DELEGATED HOUSEHOLDER DECISION

Item No.	Report of the Head of Planning, Transportation and Regeneration	
Address	277 KINGSHILL AVENUE HAYES	
Development:	Part two storey, part single storey side and rear extension, front canopy, conversion of roof space to habitable use to include a rear dormer and 2 front rooflights and outbuilding to rear for use as storage	
LBH Ref Nos:	7175/APP/2019/3606

Rev			Description	Date
CLIENT				
Mr R Kapur				
PROJECT				
277 KINGSHILL AVENUE HAYES UB4 8BP				
DRAWING				
PROPOSED REAR ELEVATION @ 1:50				
DRAWN	HTH	CHECKED	APPROVED	
TRACED		SCALE 1:50 @ A3	DATE OCT 2016	
DRAWING No.				REV
277KINGSHILL/2016/PLANNING/1

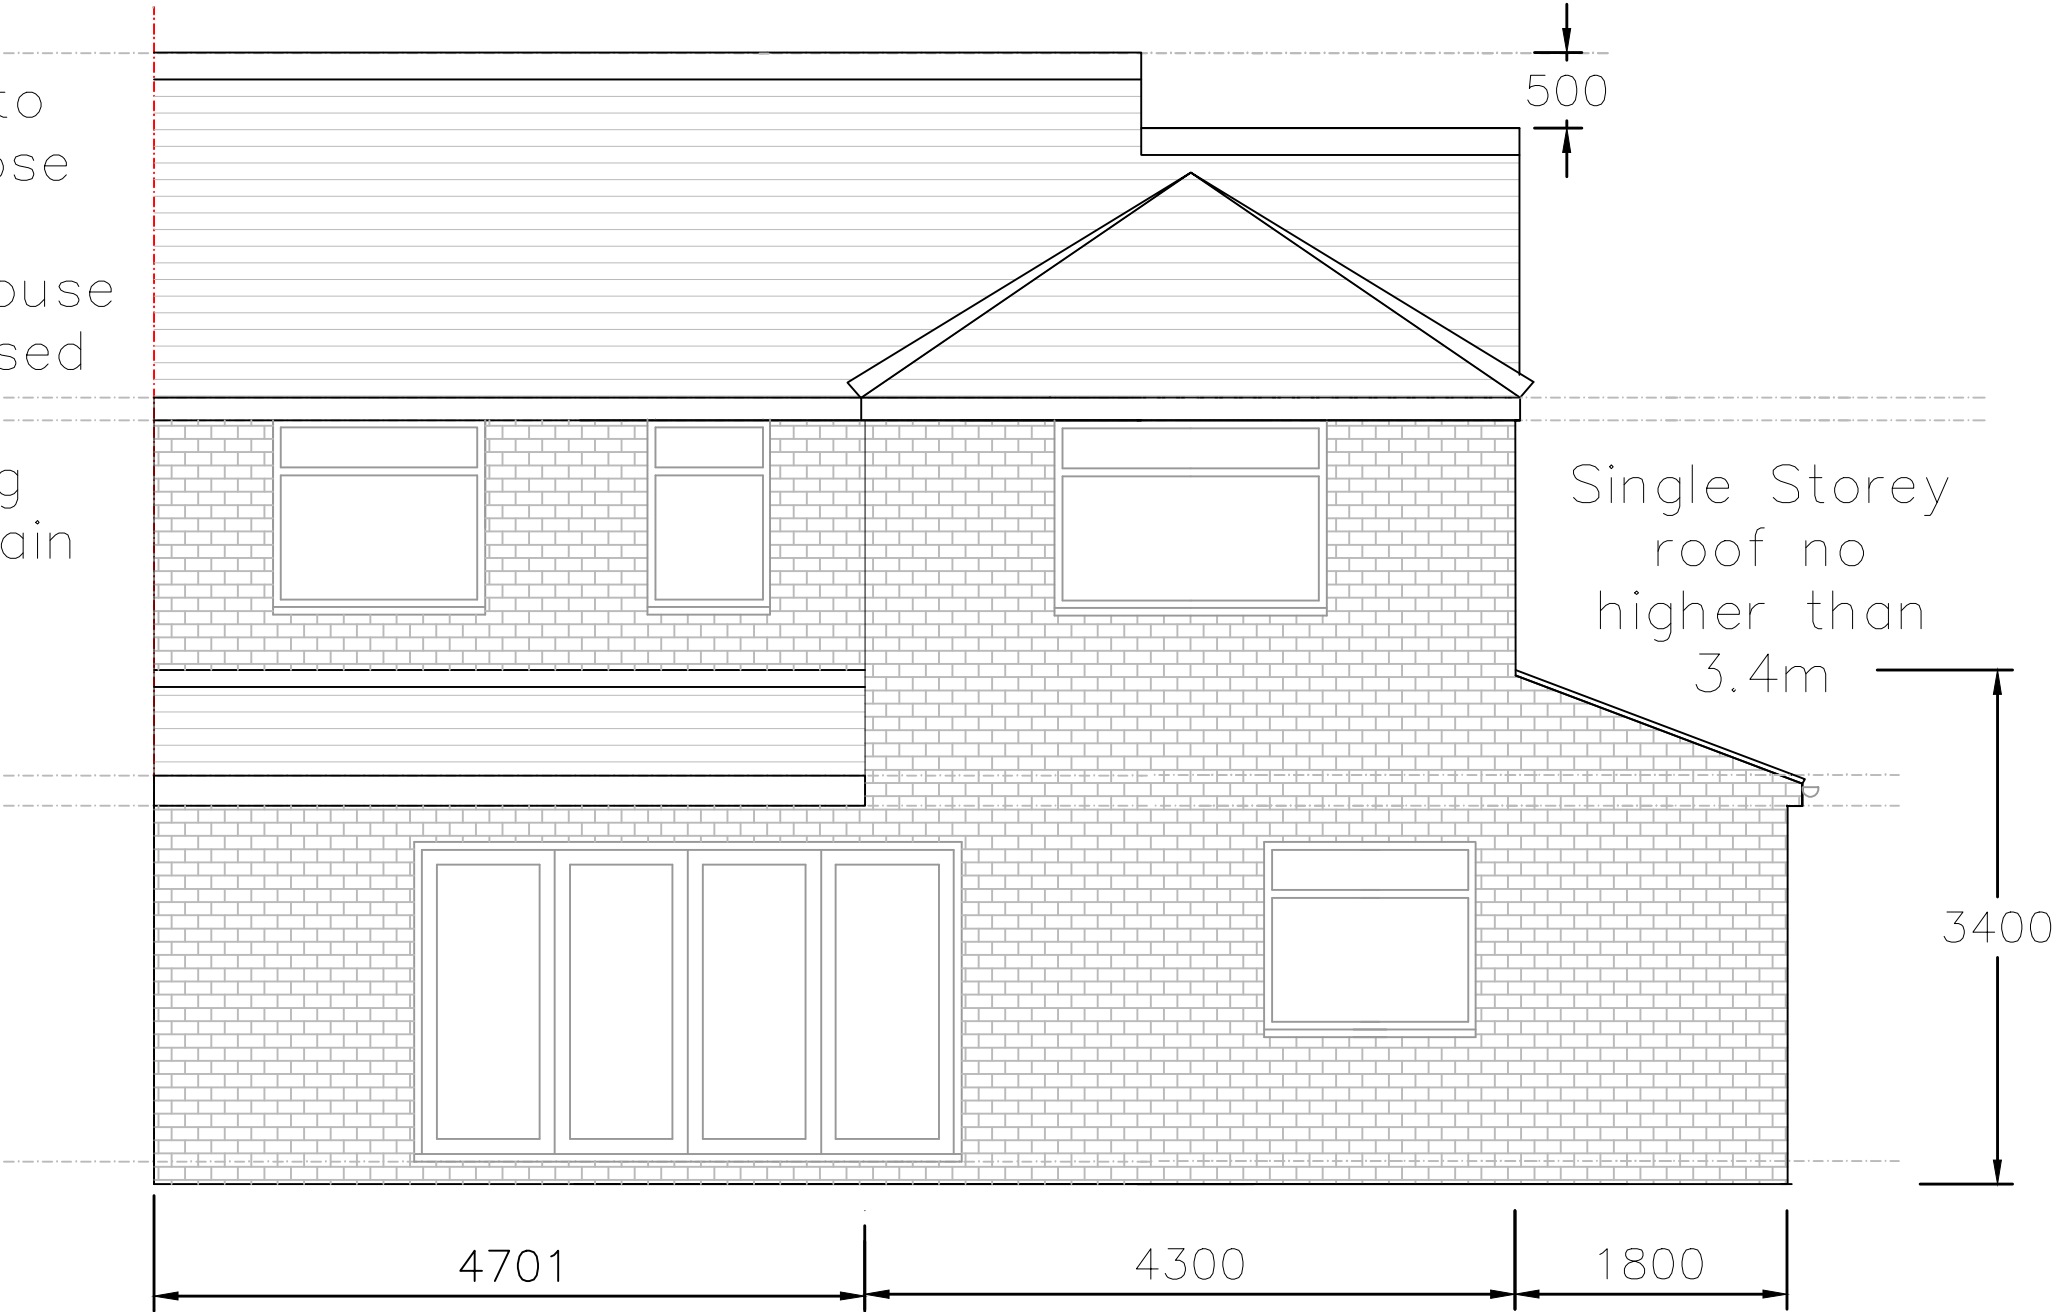
The single storey rear extension alongside the boundary with adjoining Number 279 Kingshill Avenue has been built 0.3m higher than approved. Number 279 has been

extended to the rear alongside the boundary and it is considered that the additional height would not result in an unacceptable loss of light or outlook to the occupants of this property. It is considered, on balance, that the additional height does not result in a visually incongruous form of development.

*		*
Rev	Description	Date
CLIENT		
Mr R Kapur		
PROJECT		
277 KINGSHILL AVENUE HAYES UB4 8BP		
DRAWING		
PROPOSED SIDE ELEVATION @ 1:50		
DRAWN	HTH	CHECKED
TRACED	SCALE 1:50 @ A3	APPROVED
DATE OCT 2016		
DRAWING No.		REV
277KINGSHILL/2016/PLANNING/3

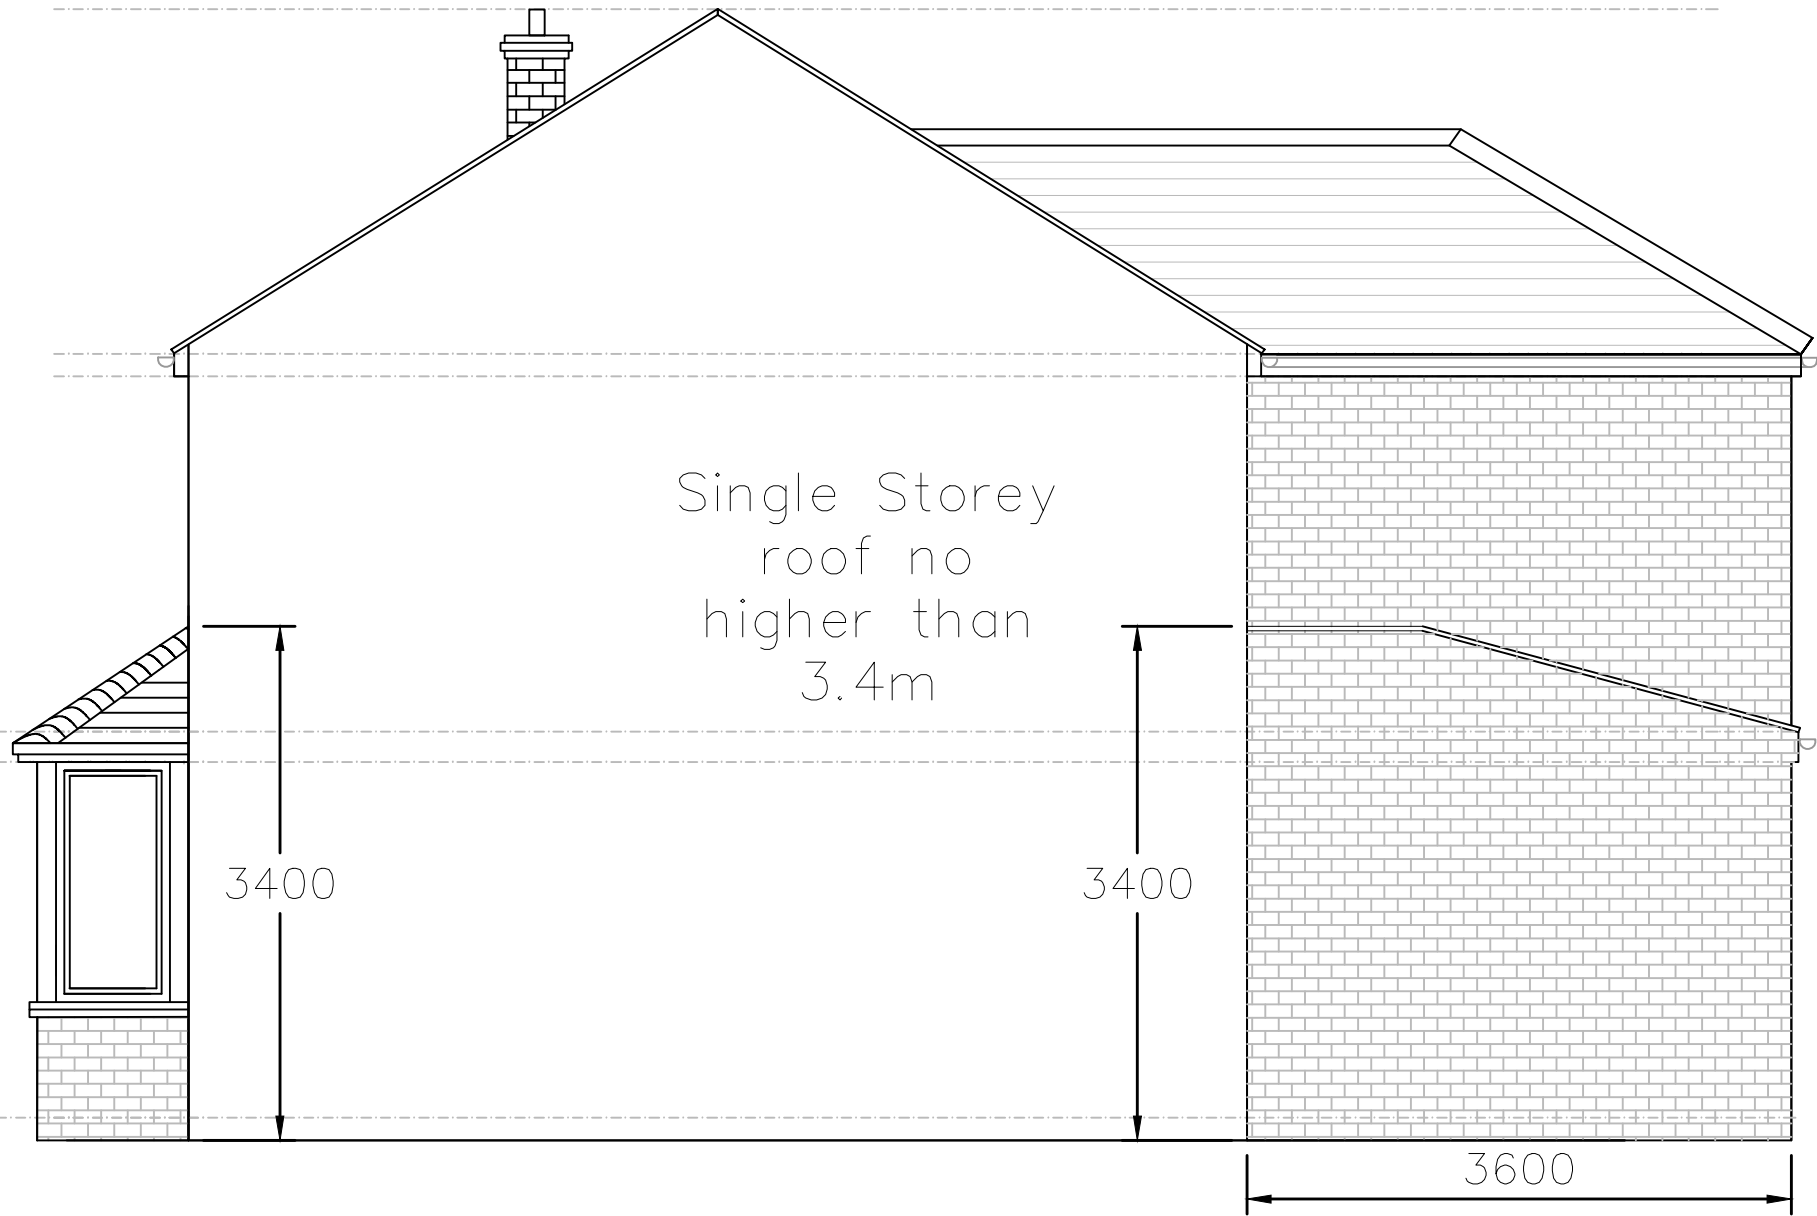
The single storey side extension which forms part of the part two storey, part single storey side extension is set 0.55m off the boundary with Dale Drive has been built 0.2m higher than approved. It is however considered, on balance, that the additional harm caused by this modest increase in height, does not justify a refusal of planning permission in this instance.

*		*
Rev	Description	Date
CLIENT		
Mr R Kapur		
PROJECT		
277 KINGSHILL AVENUE HAYES UB4 8BP		
DRAWING		
PROPOSED FRONT ELEVATION @ 1:50		
DRAWN	HTH	CHECKED
TRACED	SCALE 1:50 @ A3	APPROVED
DRAWING No.		REV
277KINGSHILL/2016/BREGS/2		A

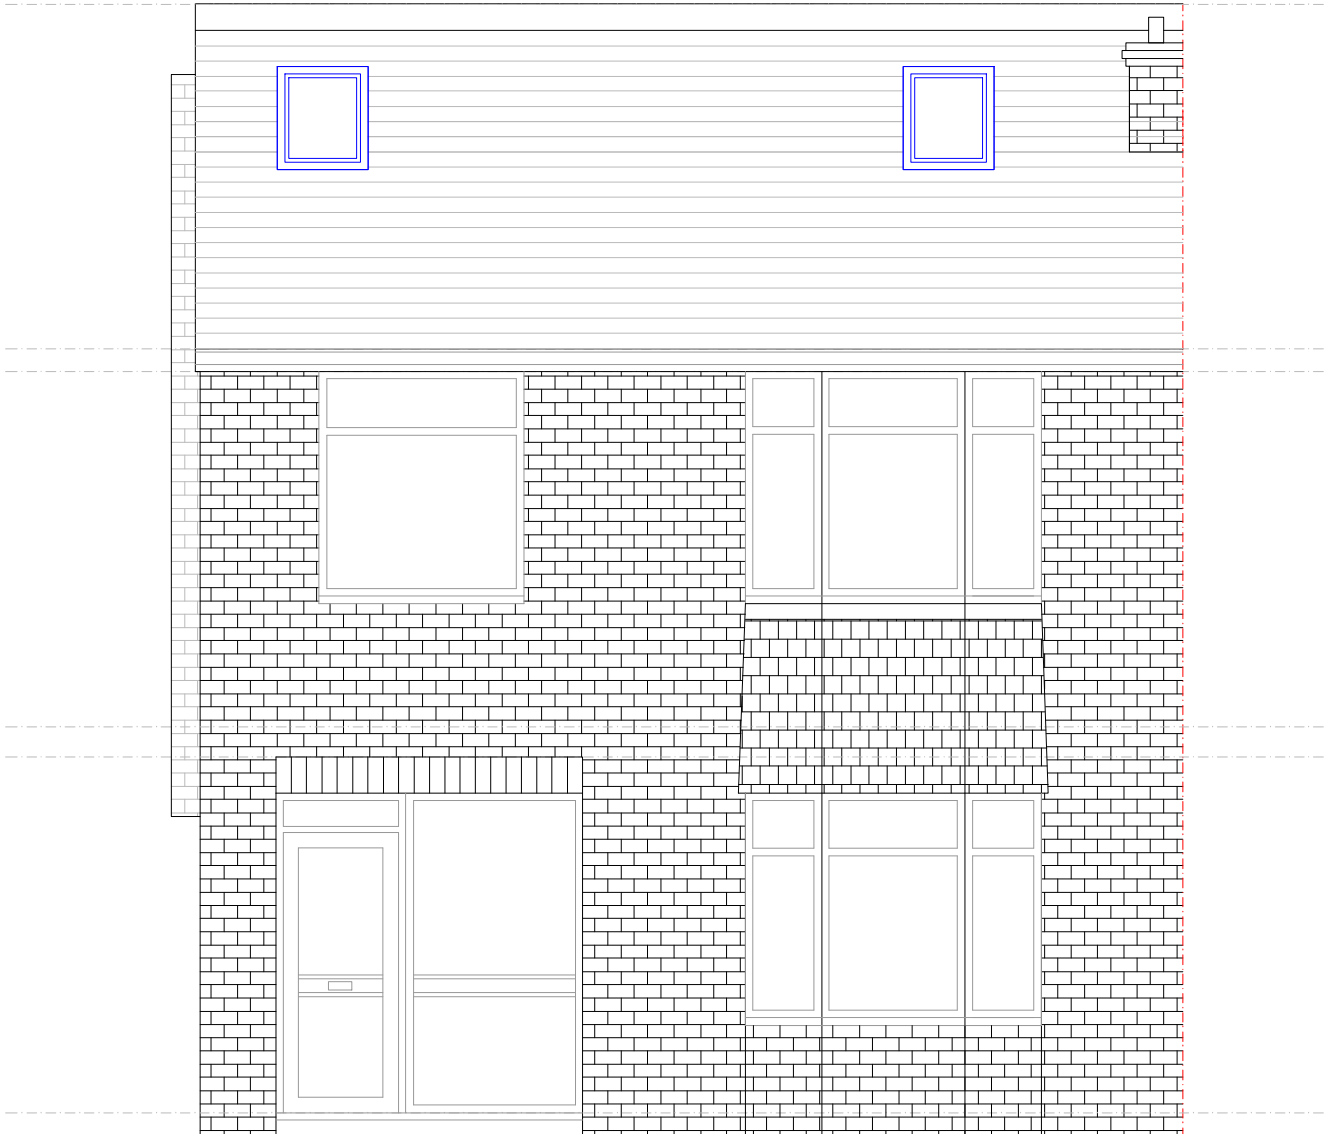
The proposed porch and front canopy constitutes a considerable change to the character and appearance of the existing property, which fails to be subordinate to the original property. This results in an unbalanced appearance between the other dwellings in wider area and impacts unduly on the character and appearance of the area in general. As such, the proposed front canopy and porch by reason of its size, scale, design and bulk results in an incongruous addition which is damaging to the architectural composition of the property and the visual amenities of the street scene and surrounding area. Therefore, the development is considered unacceptable as it fails to comply with the requirements of Policy BE1 of the Hillingdon Local Plan: Part One Strategic Policy and policies DMHB11

The proposed front canopy and porch by reason of its size, scale, bulk, width and design results in an incongruous addition which fails to harmonise with the architectural composition of the original dwelling and is detrimental to the character, appearance and visual amenities of the street scene and the surrounding area. Therefore the proposal is contrary to Policy BE1 of the Hillingdon Local Plan: Part One - Strategic Policies (November 2012) and Policies DMHB 11 and DMHD 1 of the Hillingdon Local Plan: Part Two - Development Management Policies (January 2020).

Rev		Description	Date
CLIENT			
Mr R Kapur			
PROJECT			
277 KINGSHILL AVENUE HAYES UB4 8BP			
DRAWING			
PROPOSED REAR ELEVATION @ 1:50			
DRAWN	HTH	CHECKED	APPROVED
TRACED		SCALE 1:50 @ A3	DATE MAR 18
DRAWING No.			REV
277KINGSHILL/2016/BREGS/2			A

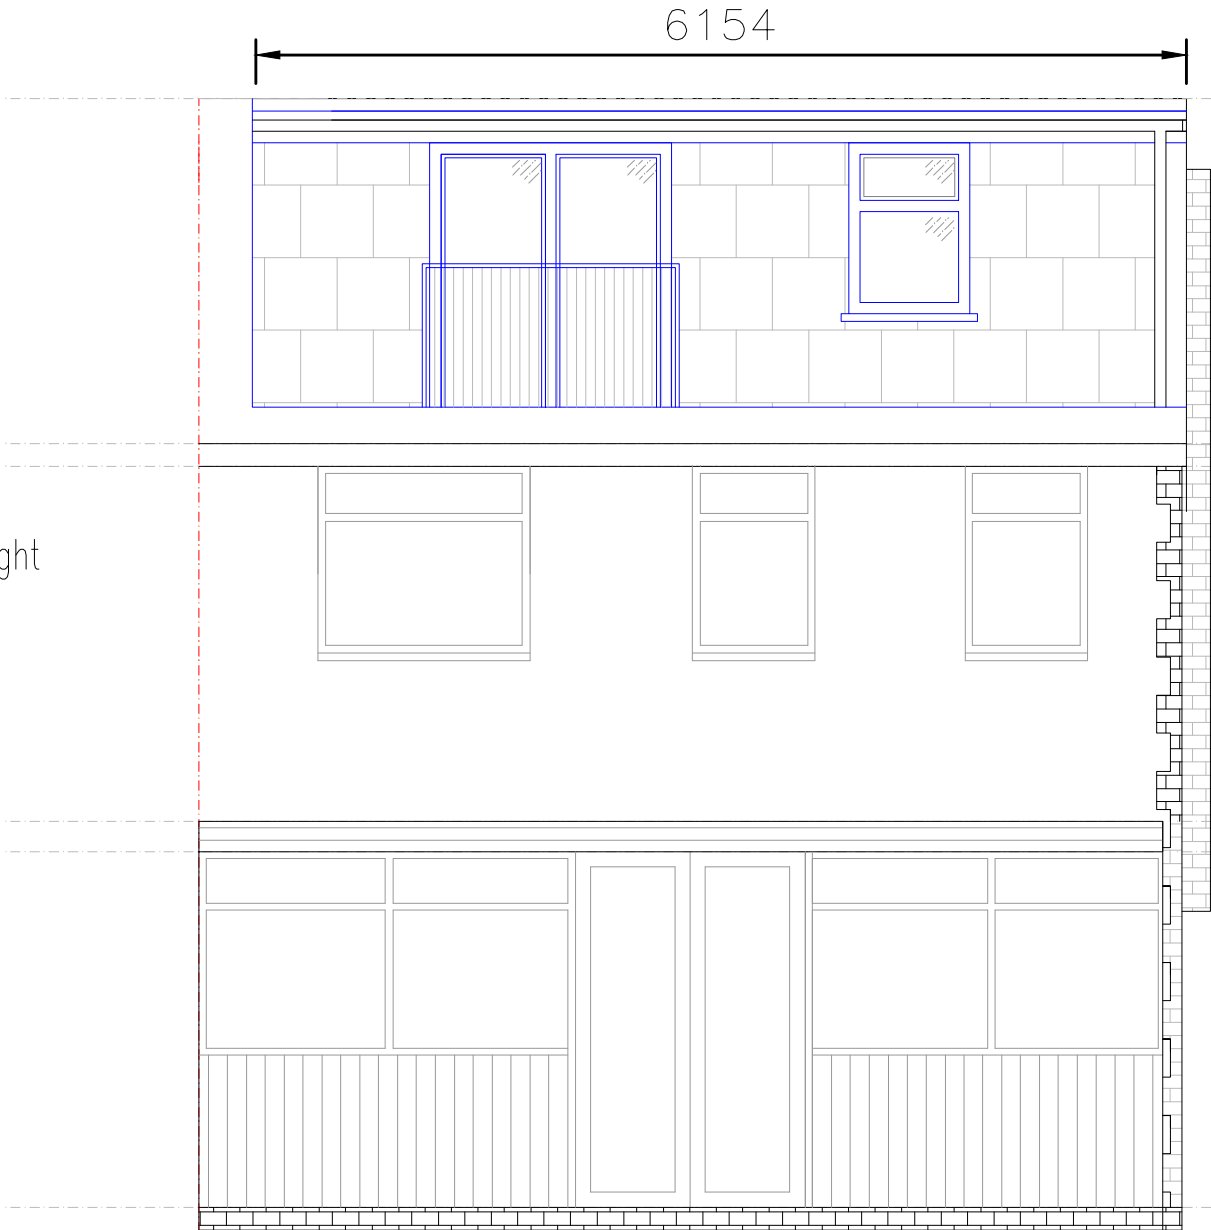
The proposed loft conversion fails to comply with the requirements of Policy DMHD 1. The roof alteration/extensions, by reason of their size, scale, bulk, and design fails to harmonise with the architectural composition of the original dwelling, and is detrimental to the character, appearance and visual amenities of the street scene and the surrounding area. Therefore the proposal would be contrary to Policy BE1 of the Hillingdon Local Plan: Part One - Strategic Policies (November 2012) and policies DHMB11 and DMHD1 of the Hillingdon Local Plan - Development Management Policies (2020).

The roof alteration/extensions, by reason of the size, scale, bulk, and design of the rear dormer window fails to harmonise with the architectural composition of the original semi-detached dwelling, is detrimental to the character, appearance and symmetry of the pair of semi-detached houses of which it forms a part and to the visual amenities of the street scene and the surrounding area. Therefore the proposal is contrary to Policy BE1 of the Hillingdon Local Plan: Part One - Strategic Policies (November 2012) and Policies DMHB 11 and DMHD 1 of the Hillingdon Local Plan: Part Two - Development Management Policies (January 2020).
